**Your ref:** 3/2021/0188  
**Our ref:** DC/21/960  
**Date:** 18-MAR-21

**Location: Land off Slaidburn Road Slaidburn Road Waddington Clitheroe BB7 3JJ**  
**Proposal: Proposed demolition of redundant stables/store buildings and the creation of a dog training facility**

#### **United Utilities Assets and Infrastructure – Objection and Request for Further Information**

SHEET:
**PROPOSED SITE
PLAN**

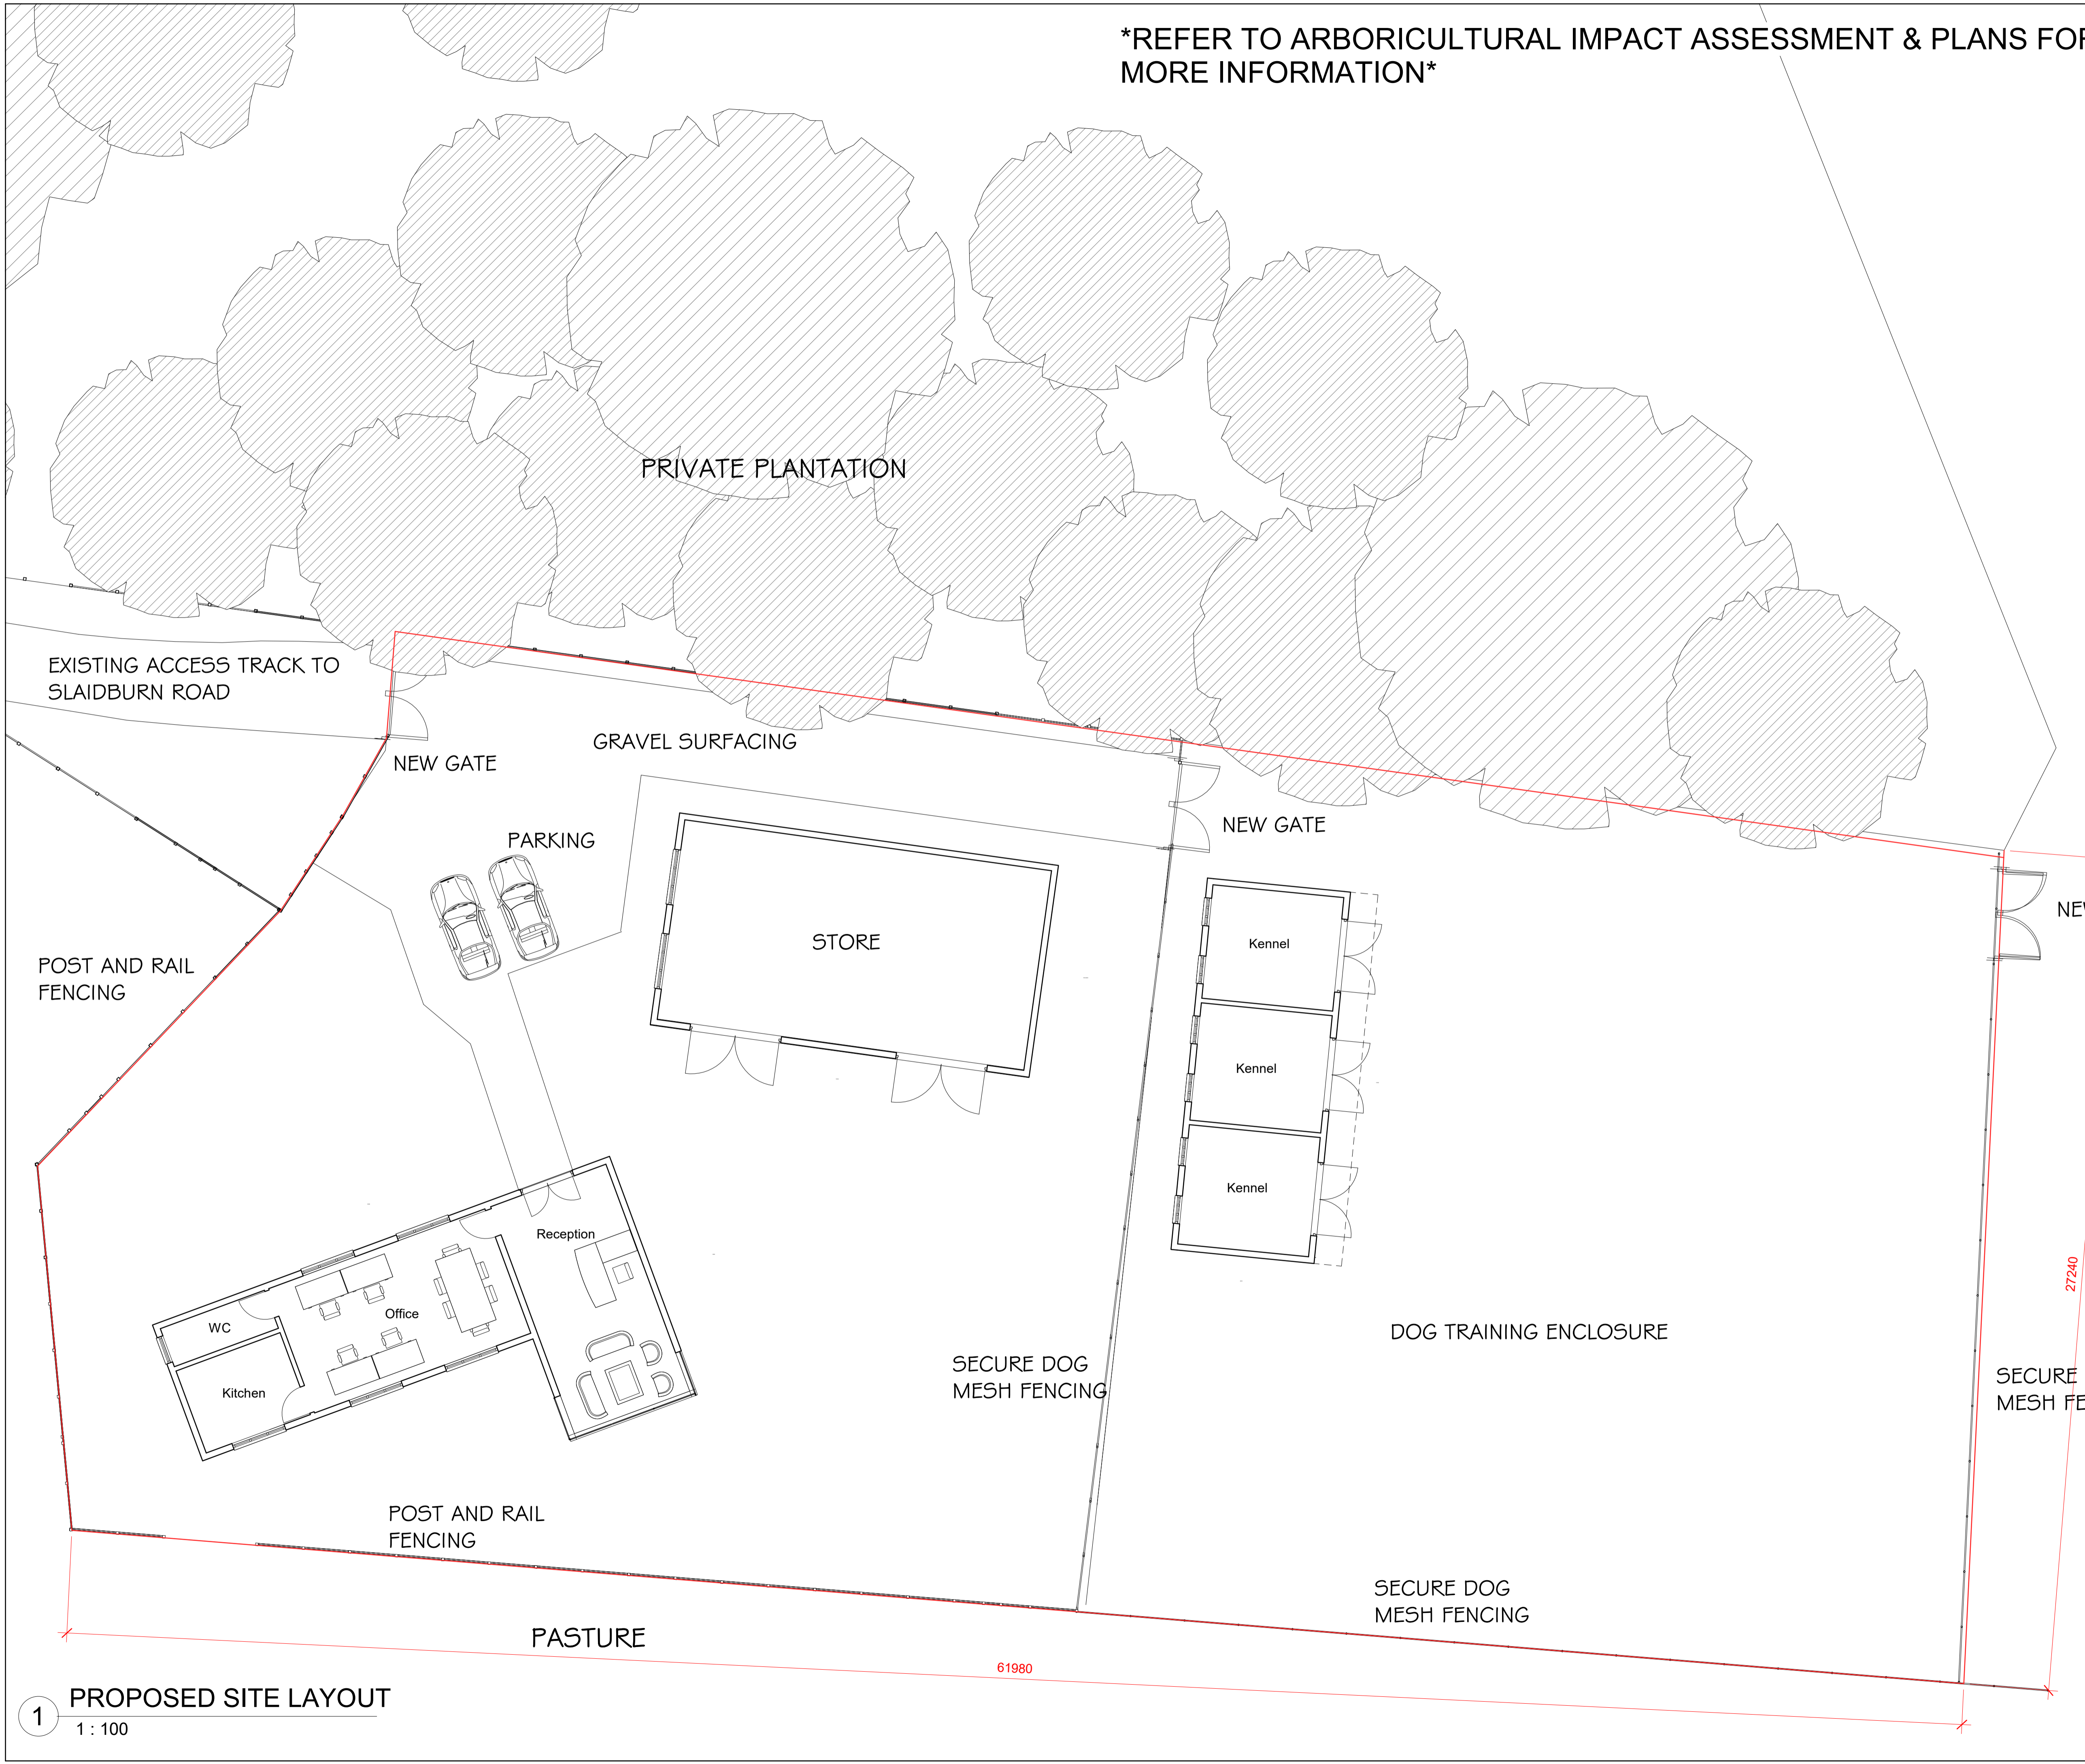
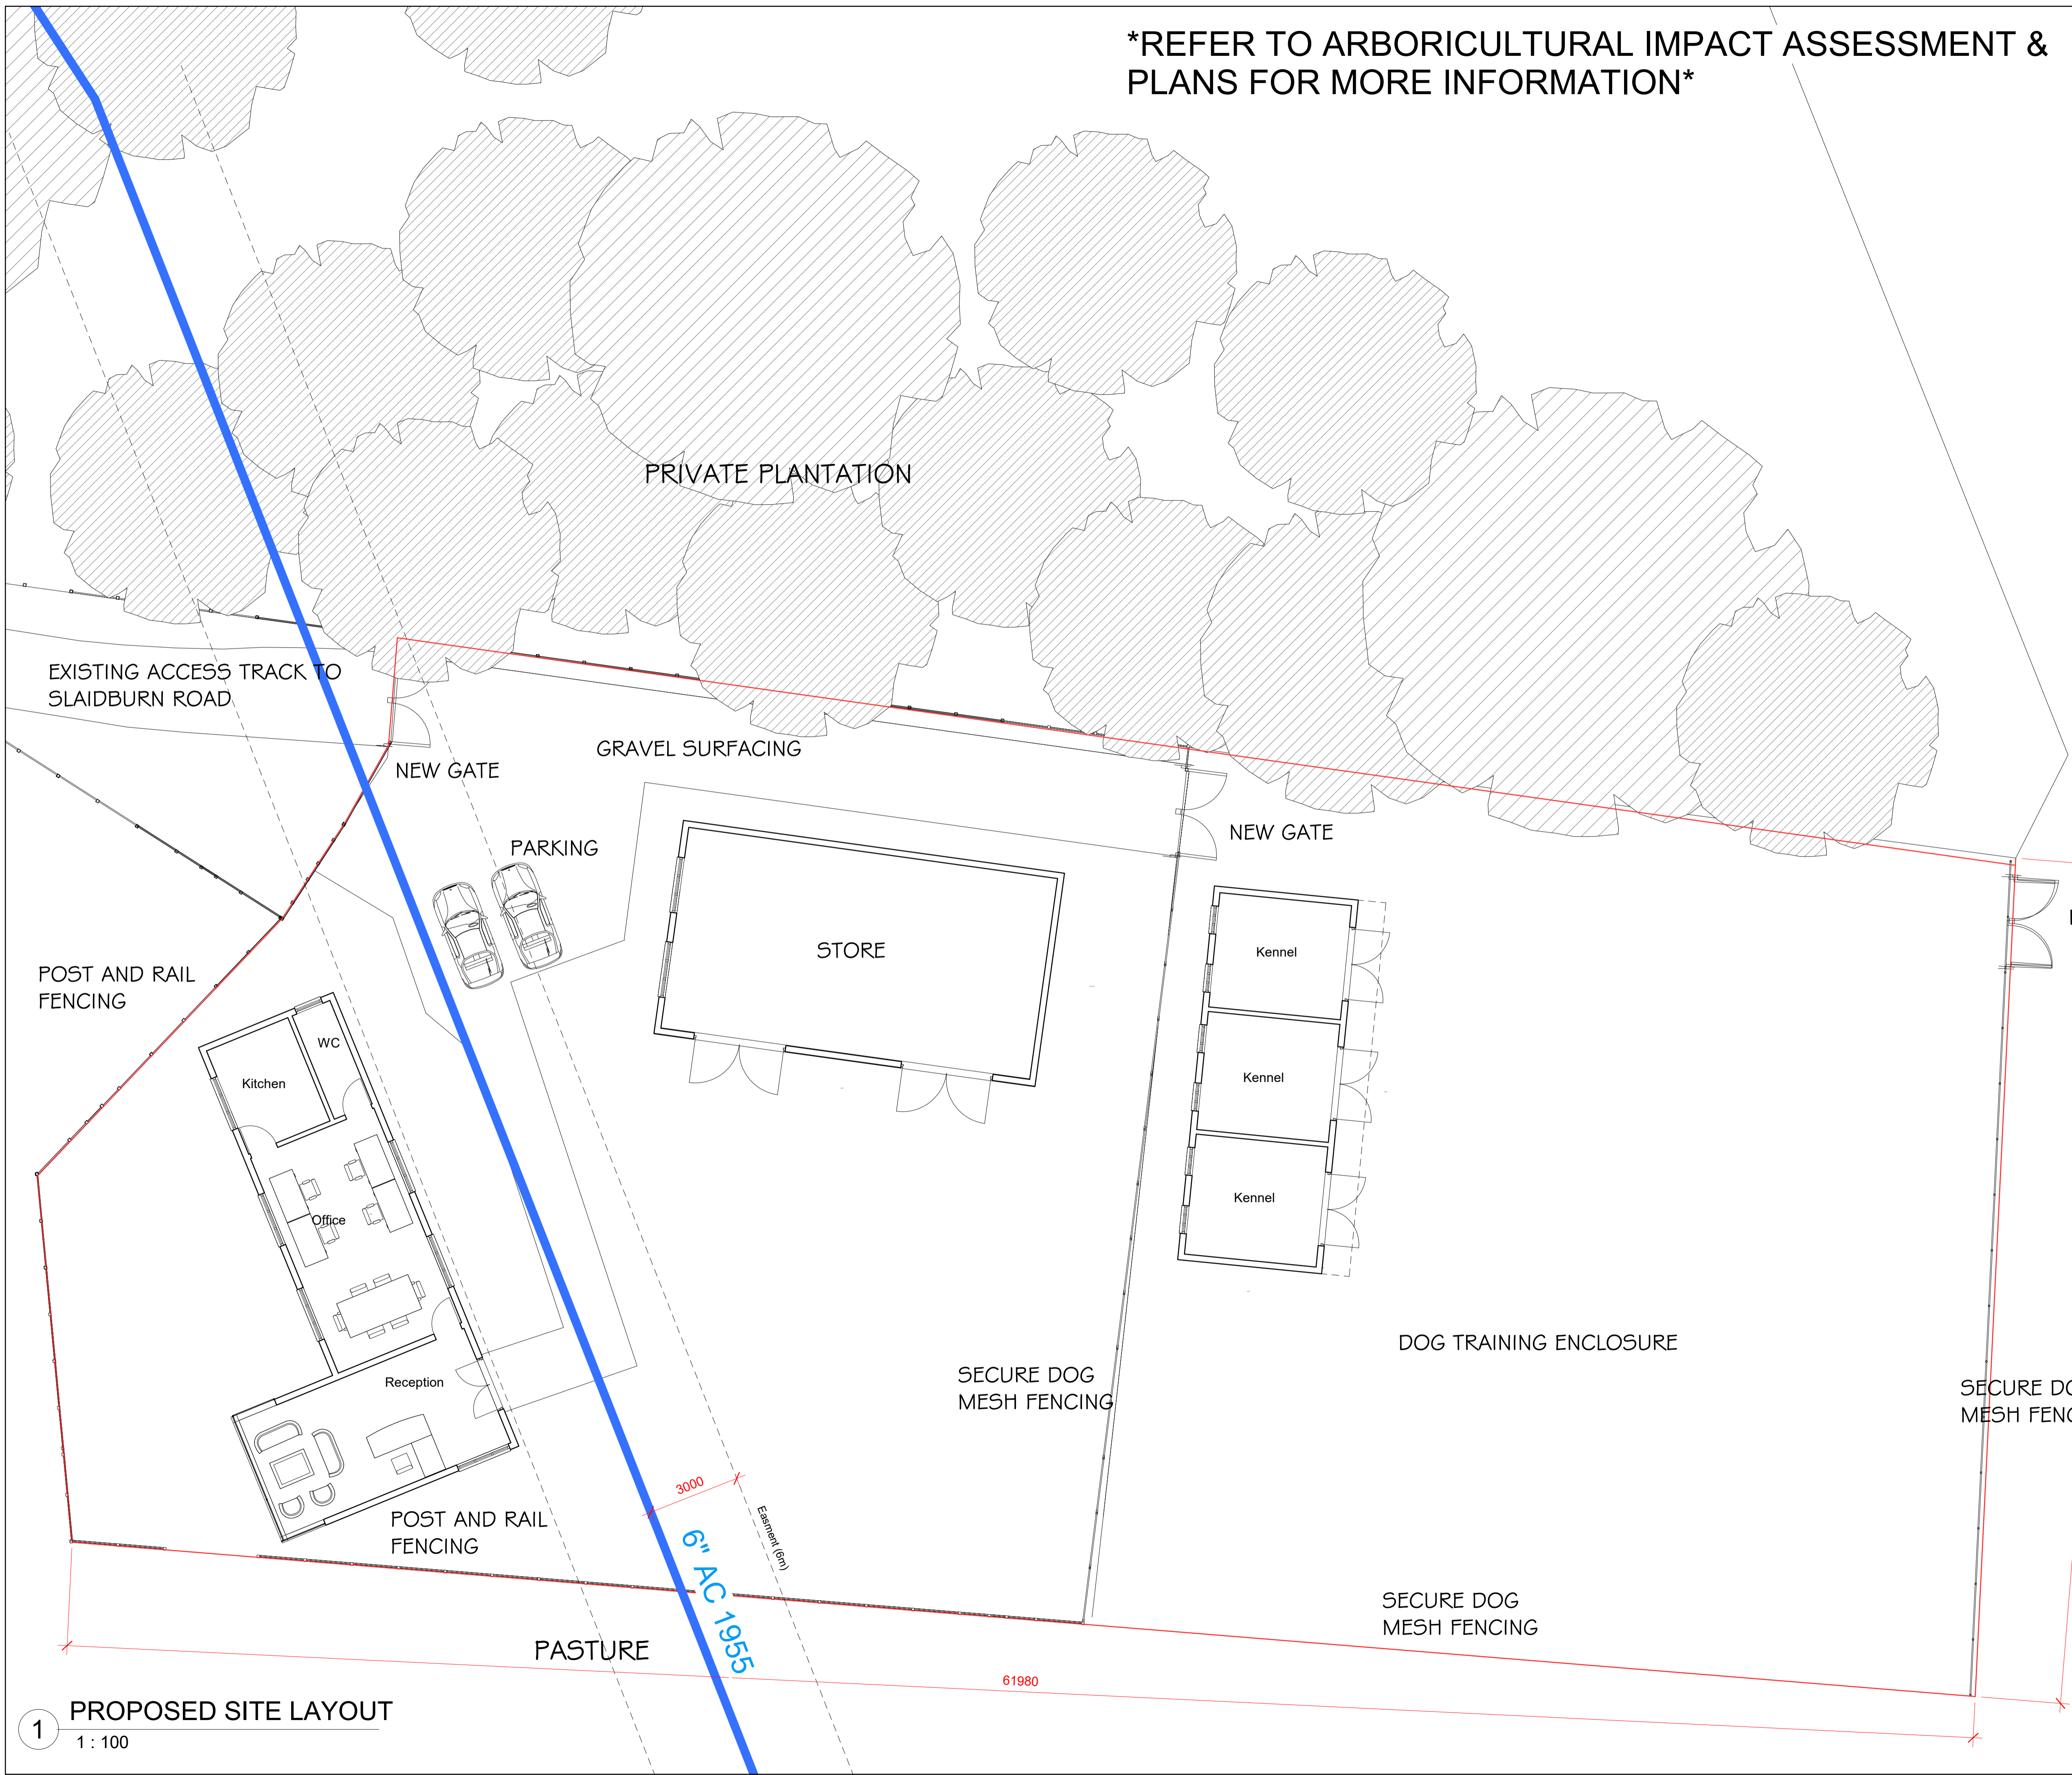
**A water main crosses the site and one of the proposed buildings is shown over or in close proximity to the main. As we need unrestricted access for operating and maintaining it, we will not permit development over or in close proximity to the main. We require an access strip as detailed in our 'Standard Conditions for Works Adjacent to Pipelines', a copy of which is enclosed. The applicant must comply with our 'Standard Conditions' document. This should be taken into account in the final site layout, or a diversion may be necessary.**

**Our current position is that we must OBJECT to this proposal until it is demonstrated that the proposed development complies with the above.**

**United Utilities has a right of Way access to Waddington High Level Service Reservoir. Reference 60/00364 which appears to be affected by the proposal. United Utilities must have unrestricted 24 hour access to the reservoir and nothing should occur that removes this right of access.**
